WEST SUSSEX COUNTY COUNCIL CONSULTATION

TO:	Arun District Council FAO: Simon Davis
FROM:	WSCC – Lead Local Flood Authority
DATE:	29 th December 2021
LOCATION:	The Cottage Shripney Road Bognor Regis PO22 9PA
SUBJECT:	BE/176/21/PL Demolition of existing dwelling and ancillary outbuildings and erection of a 66 bedroom care home with associated access, parking and landscaping. This site is in CIL Zone 3 (Zero Rated) as other development & is a Departure from the Development Plan
RECOMMENDATION:	Advice – More Information Required

Figure 3.2 Shripney Road, Shripney, Bognor Regis

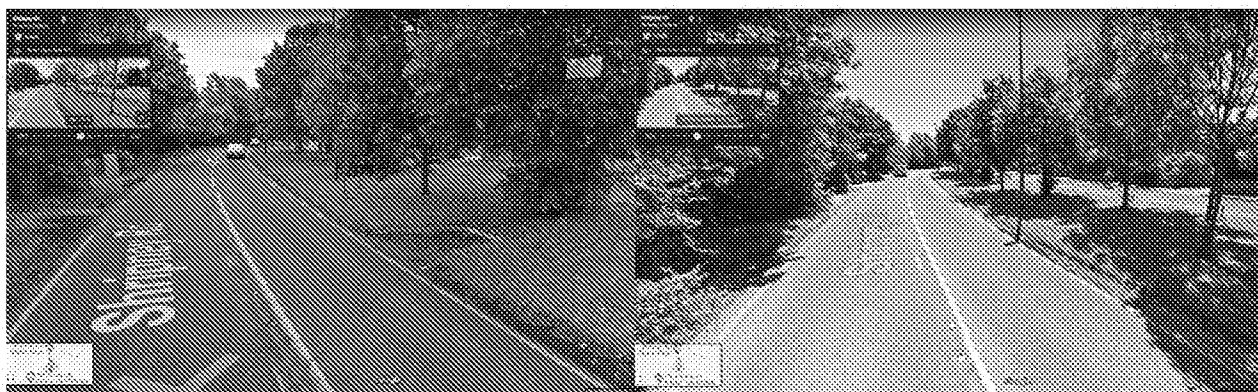
In addition, the LLFA request that, in a Flood Risk Assessment be provided as part of this application. The access to the site is shown to be at high risk from surface water flooding according to the EA's Surface Water Flood Maps.

Therefore, although the site is less than 1 ha and in Flood Zone 1, it has been identified that it could be affected by sources of flooding other than rivers and the sea and, as such, a Flood Risk Assessment should be provided. This Flood Risk Assessment should demonstrate that a safe route of access and egress can be obtained from this site.
